NORTH FALLS

Offshore Wind Farm

Applicant's Response to Natural England's Deadline 7 submissions

Document Reference: 9.115
Volume: 9
Date: July 2025
Revision: 0

Figure 1.1 Layout of the Project that has been modelled for changes to tidal current speeds and bed shear stresses

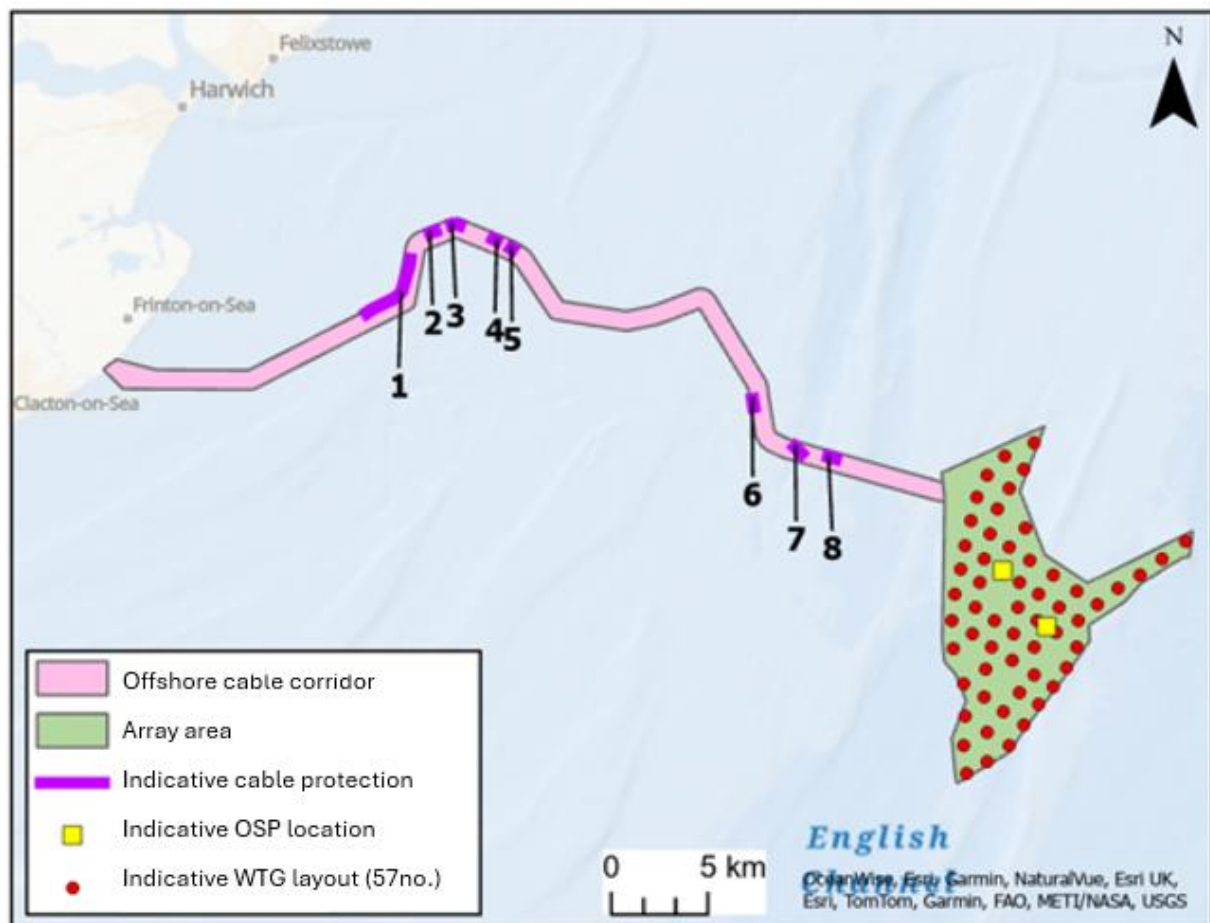
REP7-086_h	4	5.5.4 5.5.5	Natural England notes that there is a predicted change in current speed and bed shear stress of up to 5% at the eastern edge of the array. This overlaps with an area of Annex I sandbank. However, the long-term implications for changes to patterns of erosion and deposition and morphological change have not been considered.	Natural England advises that predicted changes to bed shear stress and current speed due to the project's array alone and cumulatively with other nearby OWFs need to be considered in the context of changes to patterns of erosion/deposition and seabed morphology over the lifetime of the Project. In turn, impacts to Annex I sandbanks within/adjacent to the array also need to be considered.	<p>The Applicant has undertaken modelling of concurrent effects (hydrodynamic and dispersion modelling report [REP7-041/042]). The predicted changes in tidal current speeds and bed shear stresses due to the presence of the Project alongside proposed and constructed wind farms show that there will be no cumulative effect in addition to those induced by the Project alone. Apart from Five Estuaries, there are no overlaps between the zones of influence of the Project and other wind farms (Figure 5.73 to 5.88 of hydrodynamic and dispersion modelling report [REP7-041/042]). The zone of influence of the neighbouring Five Estuaries is predicted to overlap the zone of influence of the Project, but the cumulative effect does not exceed 5% of the baseline values of both tidal current speed and bed shear stress. The cumulative changes overlap the Kentish Knock East MCZ and Annex I sandbanks inside and immediately adjacent to the array area. However, the changes in tidal current speeds and bed shear stresses would only be a few percent (up to a maximum of 5%) within these zones of encroachment. This means that given these very small magnitude changes in tidal current speeds and bed shear stresses (sediment transport potential) arising from the presence of the Project alongside proposed and constructed wind farms, the effects would</p>

REF	NE REF	SECTION	KEY CONCERN AND/OR UPDATE	NATURAL ENGLAND'S ADVICE AT D7 TO RESOLVE ISSUE	APPLICANT'S RESPONSE
					be not significant, and the overall significance of the effect would be negligible adverse (no significant effect).
REP7-086_i	5	5.5	As above, the predicted changes in current speed and bed shear stress due to the presence of scheme infrastructure (array and cable protection) have not been considered in the context of changes to patterns of erosion and accretion and, in turn, seabed morphology at the SAC and MCZ.	Natural England advises that the predicted changes in current speed and bed shear stress need to be considered in the context of changes to patterns of erosion and accretion and seabed morphology within the SAC and MCZ over the lifetime of the Project.	The Applicant has undertaken further modelling (hydrodynamic and dispersion modelling report [REP7-041/042]) and provided an updated RIAA Part 2 Benthic ecology [REP7-013/014] and MCZA Report [REP7-019/020] at Deadline 7 to address Natural England's previous comments on this matter. These assessments take into account changes in current speed and bed shear stress <i>inter alia</i> and show there will be no AEOI of the SAC or risk of hindering the conservation objectives of the MCZ.

**Figure 3.7 Predicted seabed level change during seabed preparation for the smallest turbine foundations. Horizontal hash = Kentish Knock East Marine MCZ**

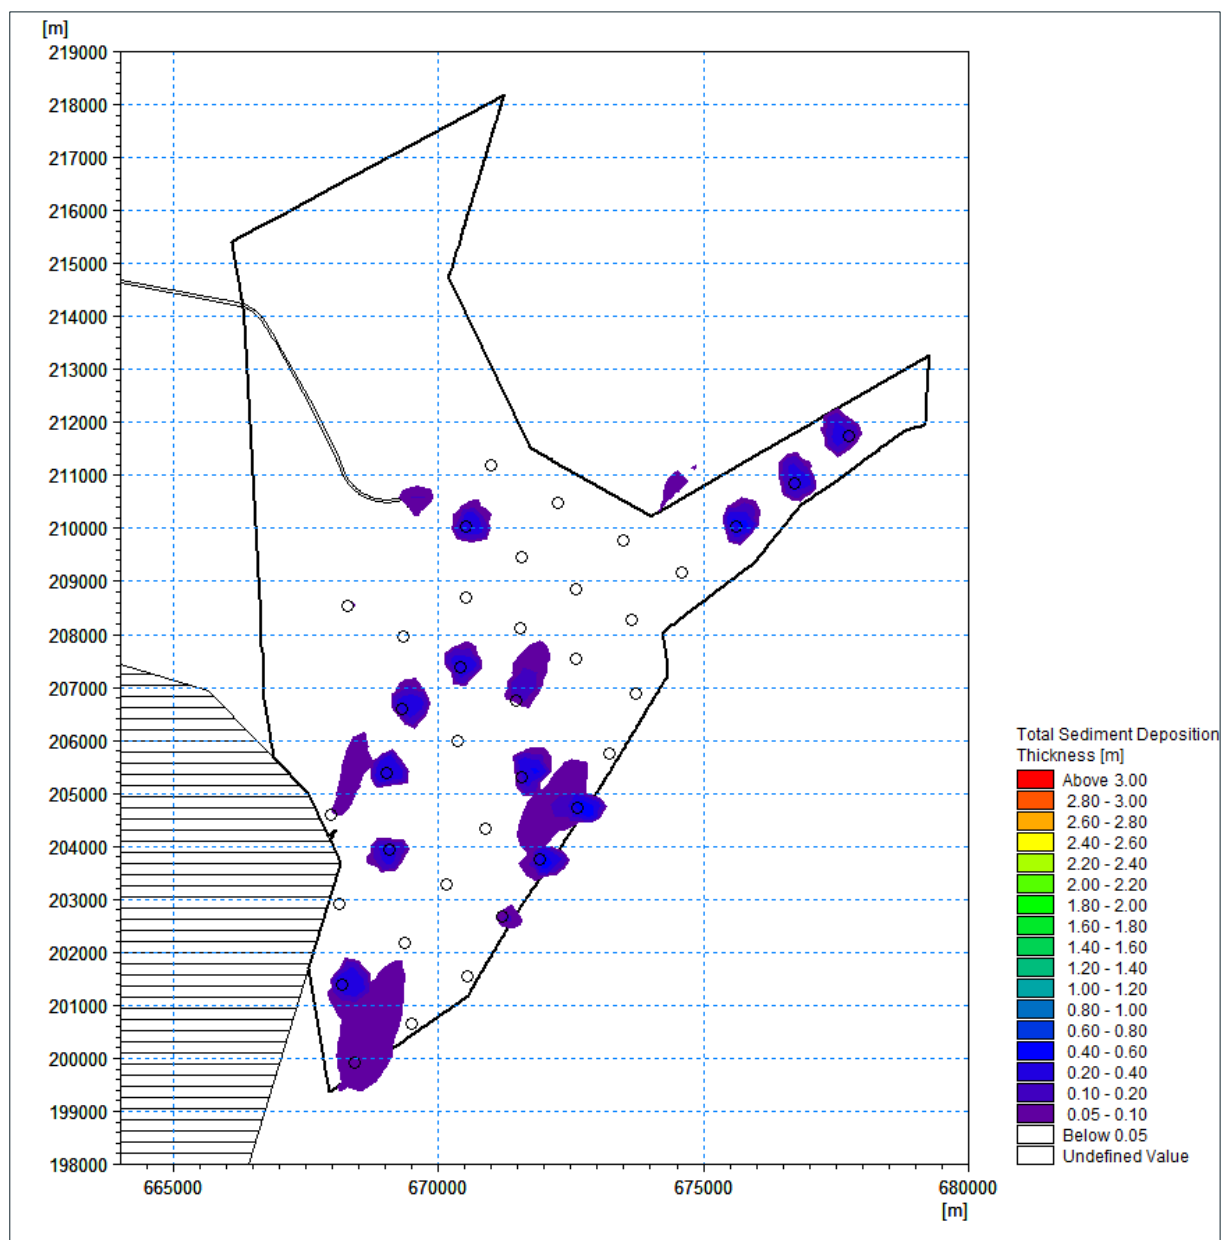
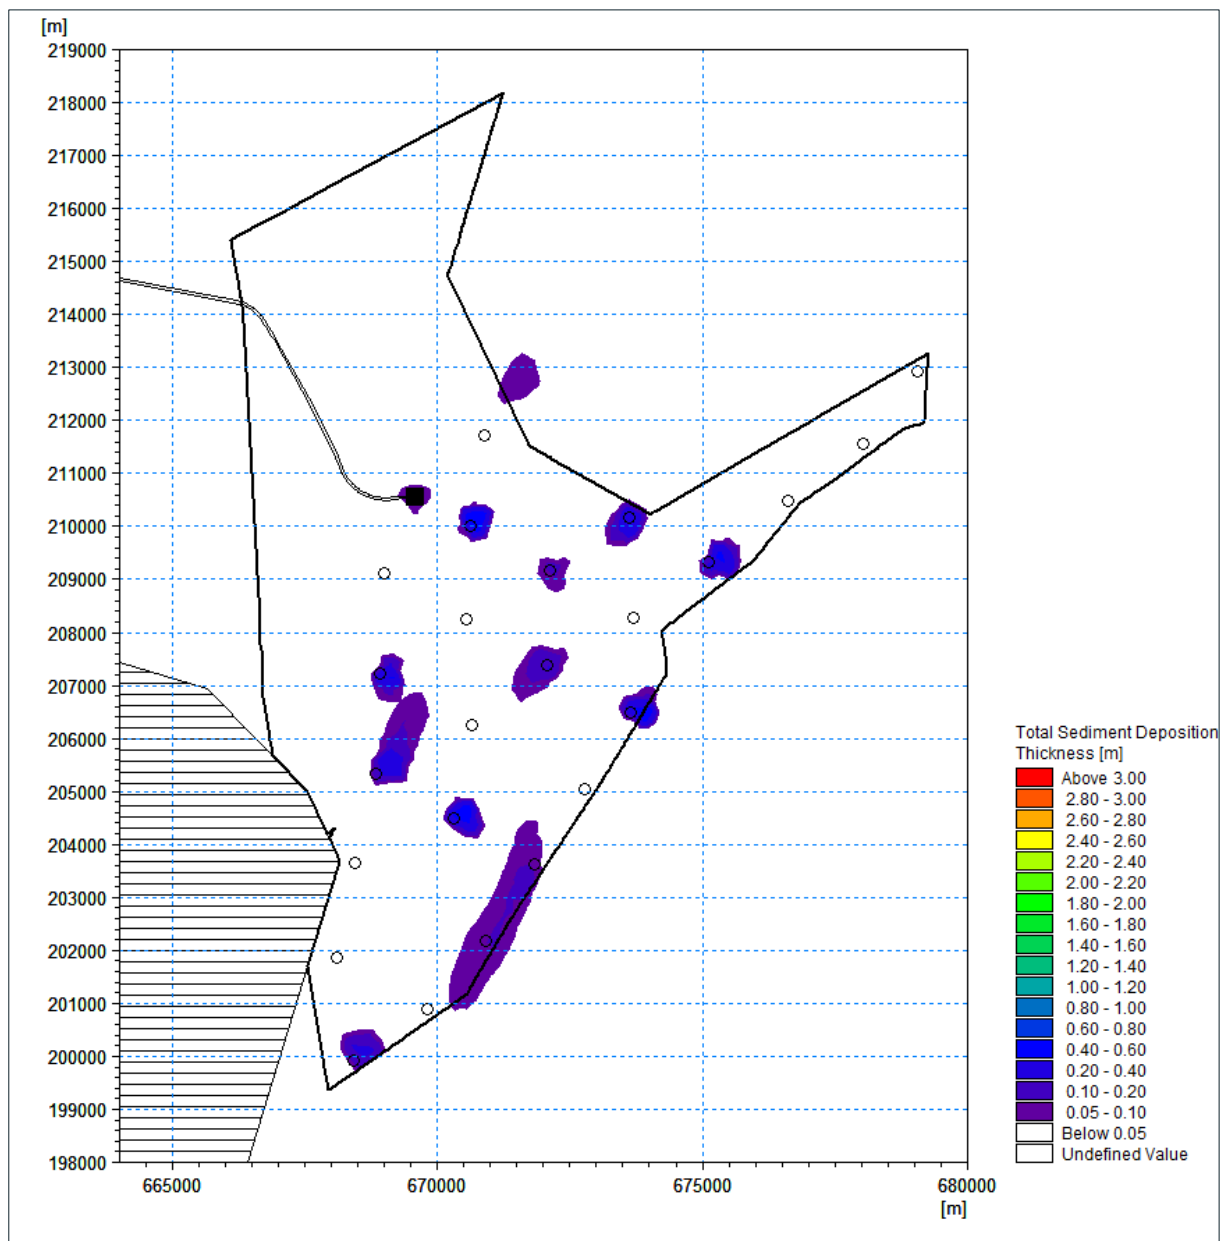
REF	NE REF	SECTION	KEY CONCERN AND/OR UPDATE	NATURAL ENGLAND'S ADVICE AT D7 TO RESOLVE ISSUE	APPLICANT'S RESPONSE
Table 1 – Hydrodynamic and Dispersion Modelling Report					
REP7-087_a	1	Figure 7.48	Natural England is concerned that the deposition modelling from seabed preparation activities during construction demonstrates that up to 60cm of sediment is likely to be deposited within Kentish Knock MCZ. This level of smothering and siltation rate change is substantially in excess of the MarESA threshold of 30cm for heavy deposition. Natural England is also concerned that these impacts have not been appropriately identified, quantified (from and ecological perspective) or evaluated in either the EIA or MCZ assessments.	<p>Natural England advises that the EIA and MCZ assessments should be updated in light of the hydrodynamic and dispersion modelling [REP4-040] deposition modelling outputs and that a realistic WCS should be used to inform assessment conclusions. We advise that the impacts within features should be fully identified, quantified, and evaluated within the appropriate ecological context in order to appropriately inform assessments. The results of the Assessment of impacts outside of MPAs also require appropriate identification, quantification, and evaluation.</p> <p>Natural England advises that unless evidence can be presented to demonstrate otherwise, we consider it likely that the achievement of the Kentish Knock East MCZ conservation objectives, which have a 'recover target' will be hindered as a result of lasting changes to structure, extent and distribution of sediment features and that of the biological communities they support.</p> <p>We draw your attention to the recent Dudgeon and Sheringham Shoal Extension Projects decisions (2024) which required MEEB for 1.8ha of cable protection within the Cromer Shoal Chalk Beds MCZ, an area which is considerably less than that which is likely to be subject to lasting impacts within Kentish Knock East MCZ as a result of deposition.</p>	<p>The Applicant provided an updated RIAA Part 2 Benthic ecology [REP7-013/014] and MCZA Report [REP7-019/020] at Deadline 7. These documents were informed by an updated hydrodynamic and dispersion modelling report [REP7-041/042] to address Natural England's previous comments.</p> <p>The updated RIAA Part 2 and MCZA take into account the predicted sediment deposition and use evidence from MarESA on sensitivity to relevant deposition depths. These assessments provide evidence that there will be no risk of hindering the conservation objectives of the MCZ.</p> <p>As the modelling validates the Applicant's previous conclusions based on expert judgement, there is no change to the assessment of effects outside MPAs, as assessed in ES Chapter 8 Marine Geology Oceanography and Physical Processes [APP-022] and Chapter 10 Benthic and Intertidal Ecology [APP-024].</p> <p>Natural England's comparison of North Falls with Sheringham Shoal and Dudgeon and Extension Projects (SEP&DEP) is extremely misleading. Natural England is well aware, the North Falls project avoided the KKE MCZ, and therefore avoided direct effects on the KKE MCZ in response to pre application advice and detailed consultation from Natural England. Therefore, in comparison to SEP&DEP's 1.8ha of direct long term direct habitat loss due to cable protection placed within an MCZ, North Falls will have zero impact as it has zero cable protection in the MCZ. MEEB was not required for indirect effects for SEP&DEP (or any other consented offshore wind farms).</p> <p>North Falls will only have short term temporary indirect effects on the eastern edge of the KKE MCZ as a result of sediment deposition. It should be noted that SEP&DEP were not required to quantify the spatial area of sediment deposition as has been requested by Natural England for North Falls.</p>

REF	NE REF	SECTION	KEY CONCERN AND/OR UPDATE	NATURAL ENGLAND'S ADVICE AT D7 TO RESOLVE ISSUE	APPLICANT'S RESPONSE
					<p>As noted above, MEEB has never been required for an offshore wind farm as a result of <u>indirect</u> effects.</p> <p>Thus, the Applicant considers there is substantial evidence and precedent to support the position that North Falls will not hinder the conservation objectives of the KKE MCZ and therefore MEEB should not be required.</p>
REP7-087_b	2	Figures 5.52-5.75	Natural England advises that whilst we have no concerns that the modelled changes in peak mean spring bed flow velocities (and associated changes in bed shear stresses) are below the MArESA thresholds and therefore unlikely to directly alter benthic communities, we question whether the predicted changes in velocities and shear stresses will result in changes to the sediment character within the zones of influence which results in indirect changes to the extent and distribution of benthic communities within the array.	Natural England advises that the EIA currently fails to set the results of the hydrodynamic modelling in any ecological context. We advise that all relevant assessments are updated to appropriately consider changes to benthic receptors as a result of predicted changes in hydrodynamic conditions in the vicinity of the array area.	The Applicant has undertaken further modelling (hydrodynamic and dispersion modelling report [REP7-041/042]) and provided an updated RIAA Part 2 Benthic ecology [REP7-013/014] and MCZA Report [REP7-019/020] and these include additional detail on changes in current speeds and bed shear stress. As these represent the most sensitive benthic receptors and the modelling validates the Applicant's previous conclusions based on expert judgement that there would be no significant effect, there is no change to the conclusions presented in ES Chapter 8 Marine Geology Oceanography and Physical Processes [APP-022] and Chapter 10 Benthic and Intertidal Ecology [APP-024] .
